WILLOWTREE PLANNING

REF: WTJ23-225

RE: REQUEST FOR ADDITIONAL INFORMATION - CROWS NEST - OSD - SITE B (SSD-61400212)

Sheet title  
SOLAR ACCESS

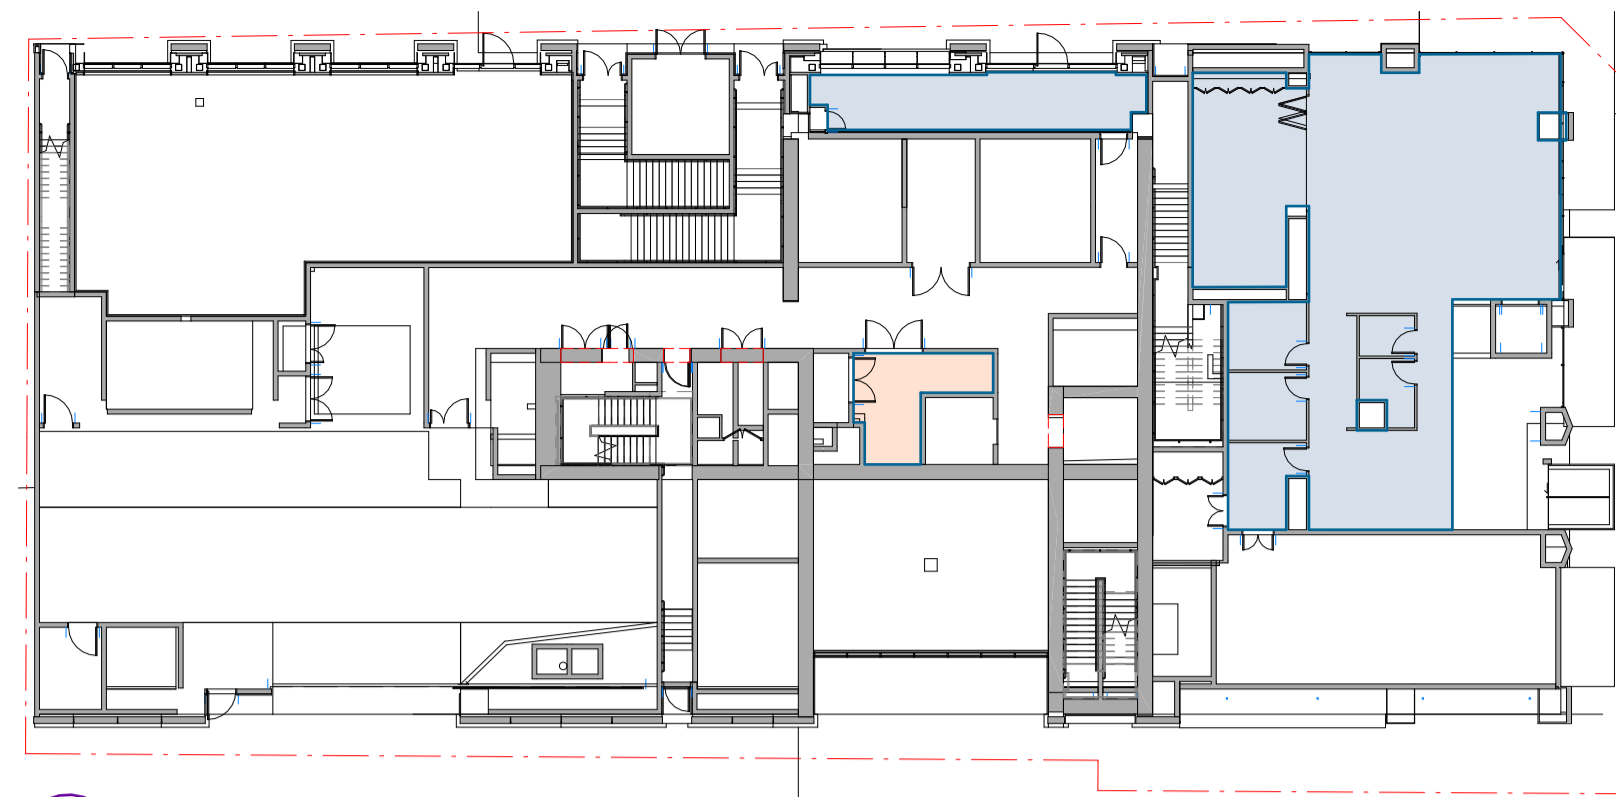
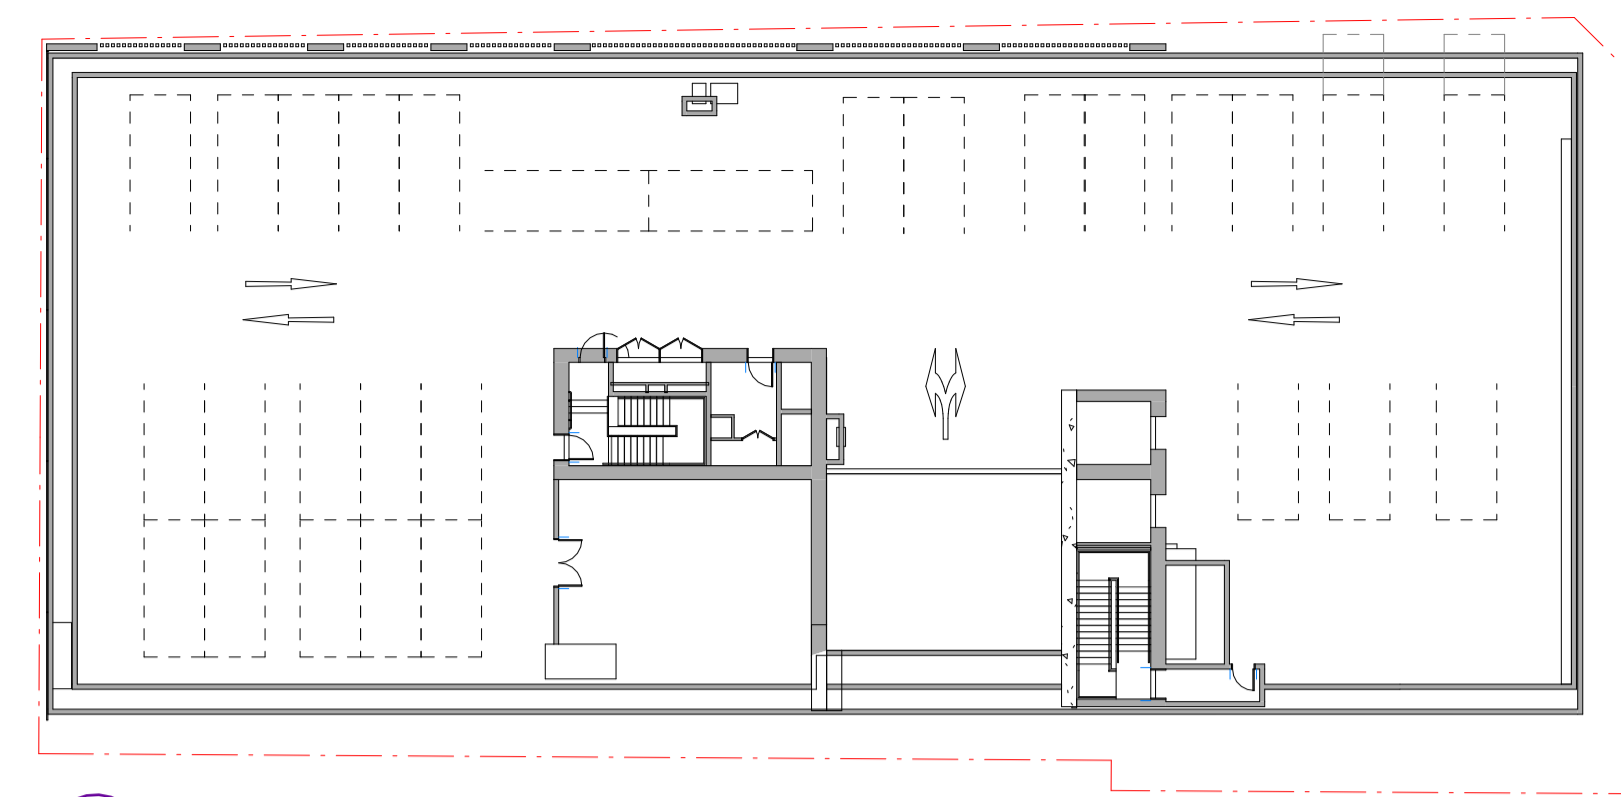
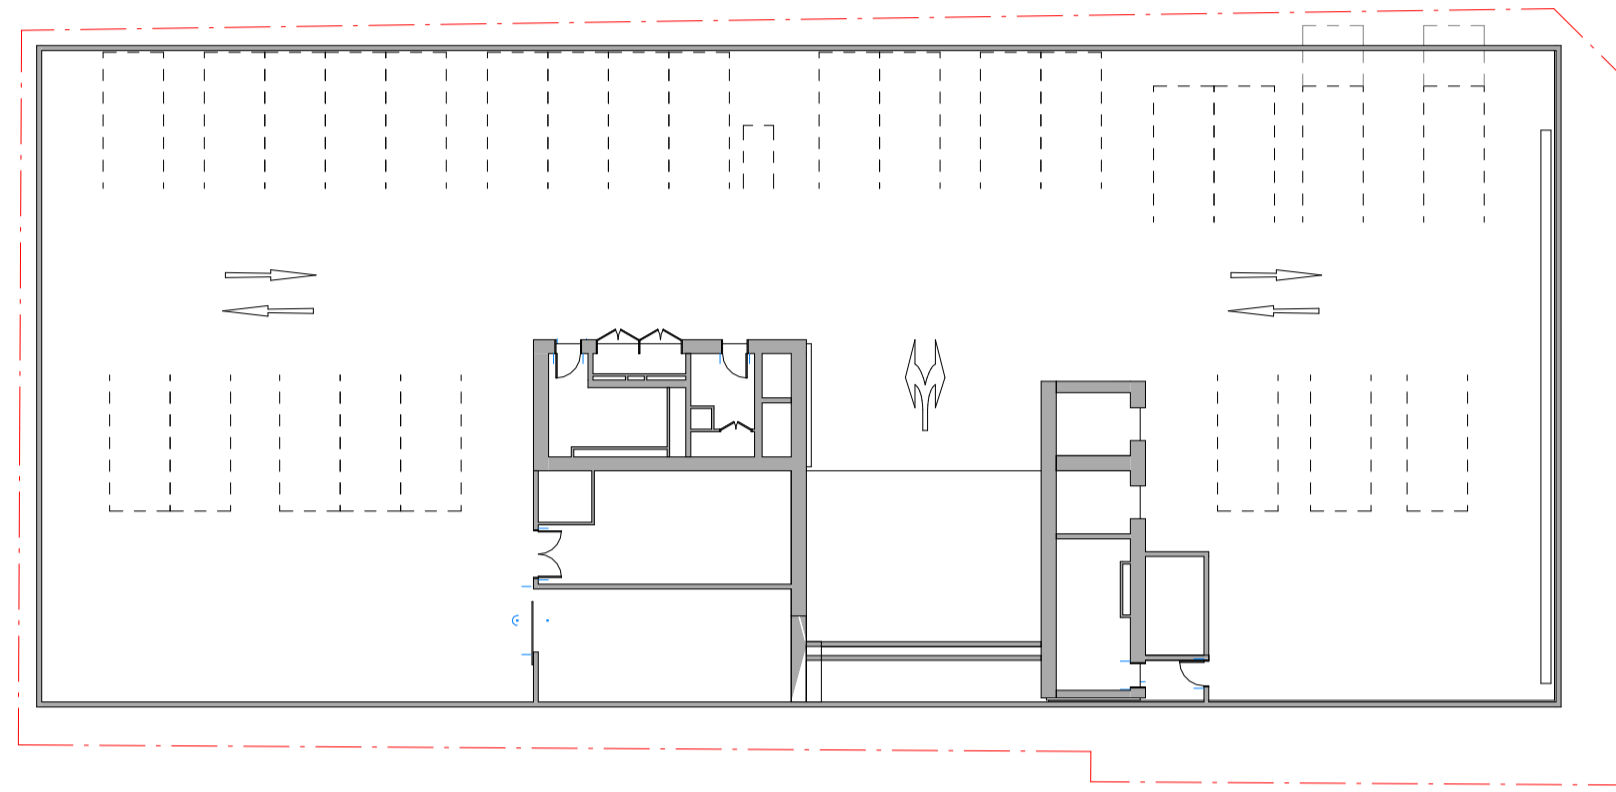
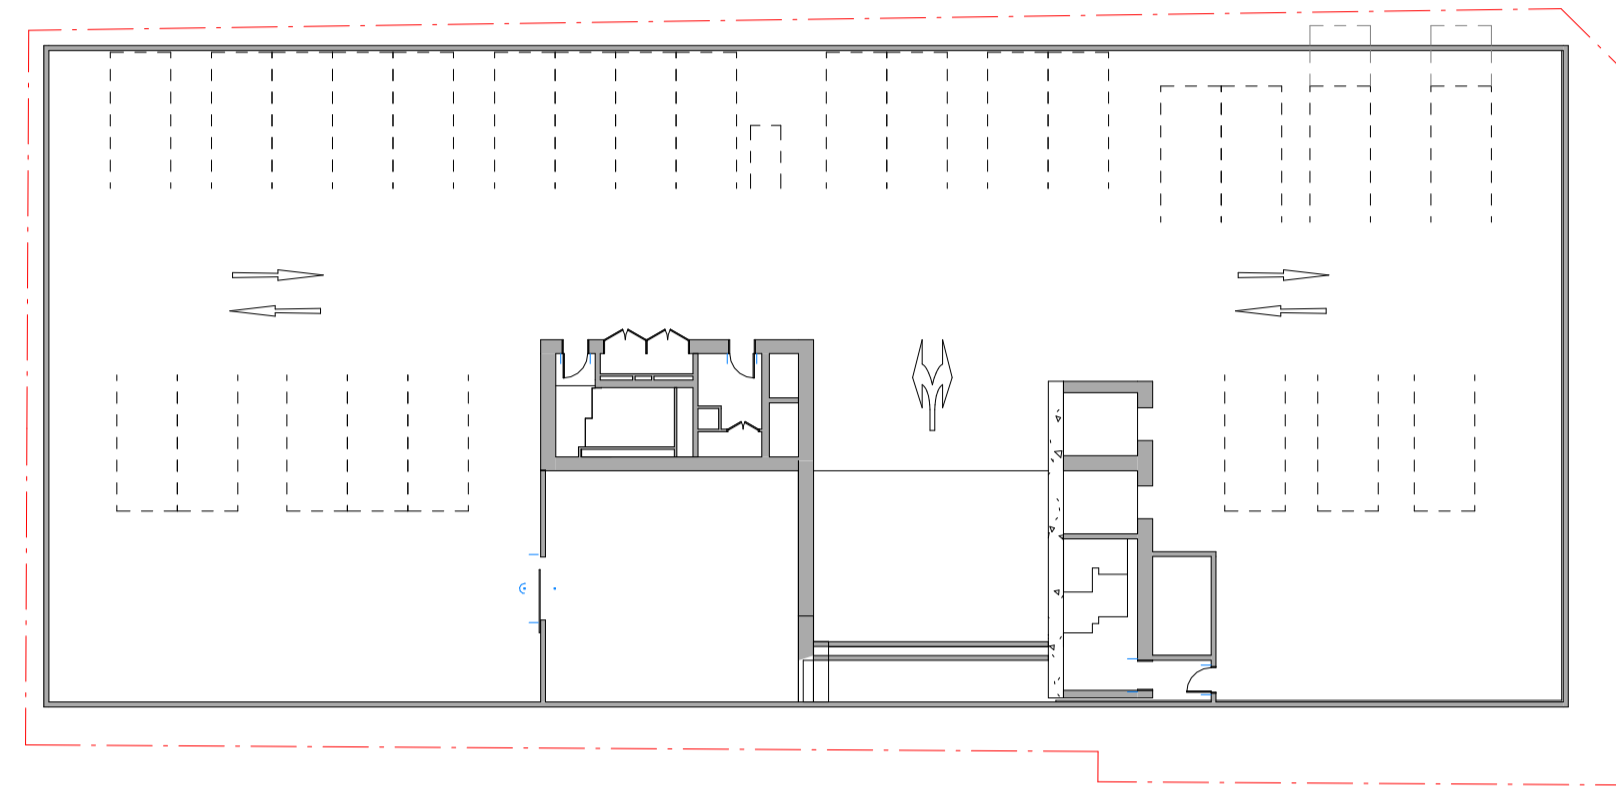
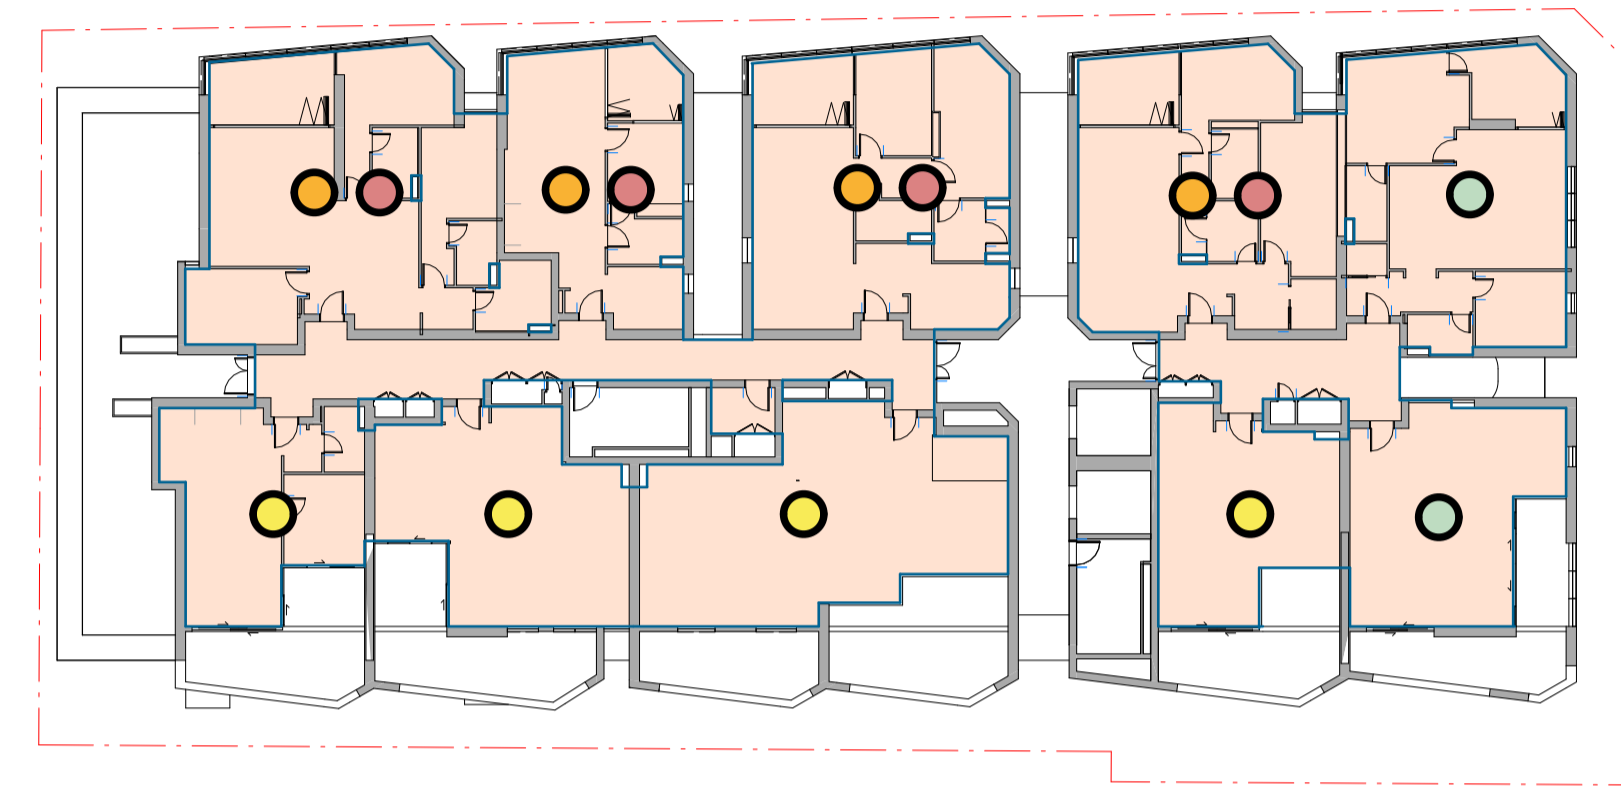
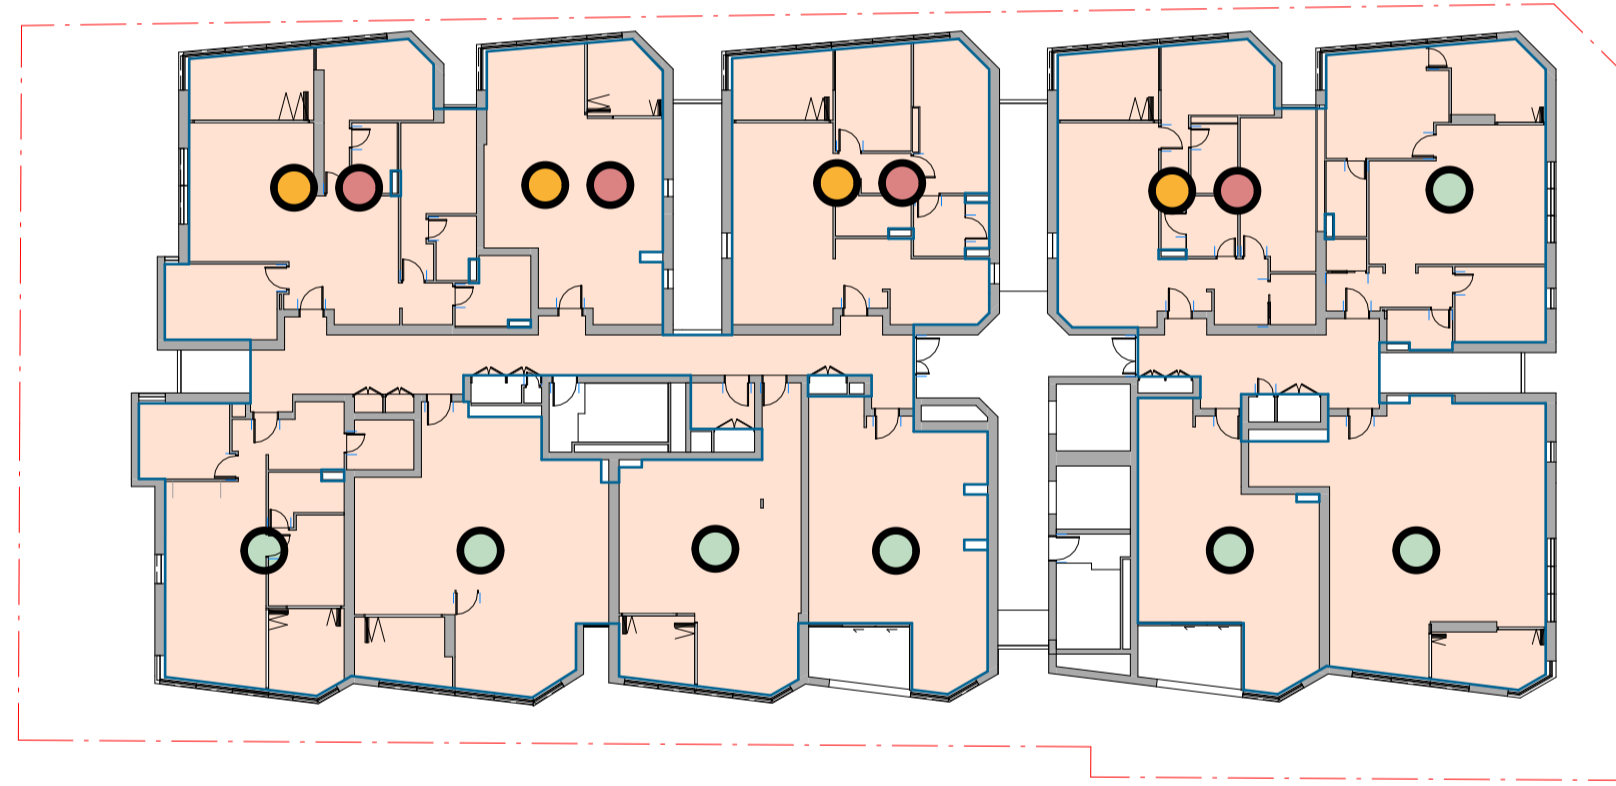
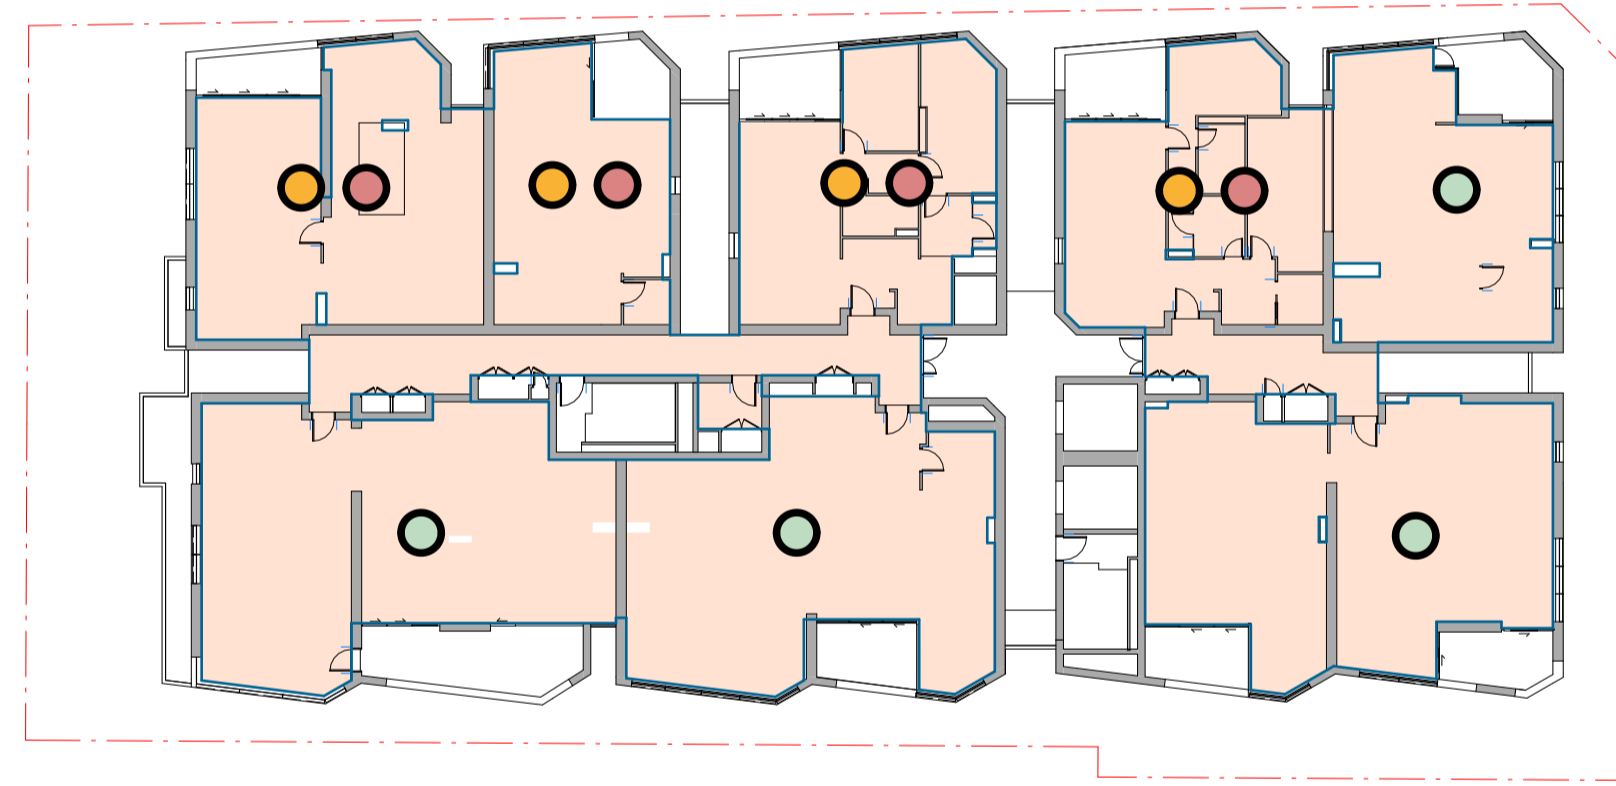
Table 1: Response Matrix	
Department's Comments	Proponent Response
1. Solar Access	
How the proposal maximises solar access, including identifying: i. the number of apartments that receive two or more hours of solar access ii. the extent of solar access received by those apartments that receive less than two hours of solar access; and iii. the extent of apartments that receive no direct solar access.	A detailed solar access assessment has been undertaken in accordance with the ADG requirements (see Appendix 1). The assessment identifies as follows: • 72 units (59%) receive a minimum of 2 hours sunlight between 9am-3pm at mid winter. • The extent of solar access received by those apartments that receive less than two hours of solar access is shown in Appendix 1. Non-compliant units on the western façade will achieve approximately 1hr 45mins solar access between 3:15pm and sundown (4:54pm). Non-compliant units at Level 08 on the eastern façade will achieve 1 hour of direct sunlight between 9am-3pm at mid winter. • 46 apartments (38%) receive no direct sunlight between 9am and 3pm at mid-winter, Notwithstanding the non-compliance identified above, the proposal is considered to deliver acceptable residential amenity outcomes on merit, having regard to the following considerations: • The building orientation and envelope has been established through the approved Concept Proposal (SSDA-9579), which limits the scope for achieving full solar access compliance within the detailed design phase. • The apartments achieve exceptional residential amenity through the provision of generous private open space and premium outlook, including expansive southerly views toward the city and Sydney Harbour.

Substantial communal open space is provided at roof level, which receives excellent solar access throughout the day and provides high-quality recreation areas accessible to all residents. These above mentioned amenity benefits appropriately compensate for the reduced solar access to affected apartments. The proposal therefore demonstrates that while numeric compliance with the ADG solar access objective is not achieved, the development delivers appropriate residential amenity through alternative design responses that are consistent with the objectives of the ADG.
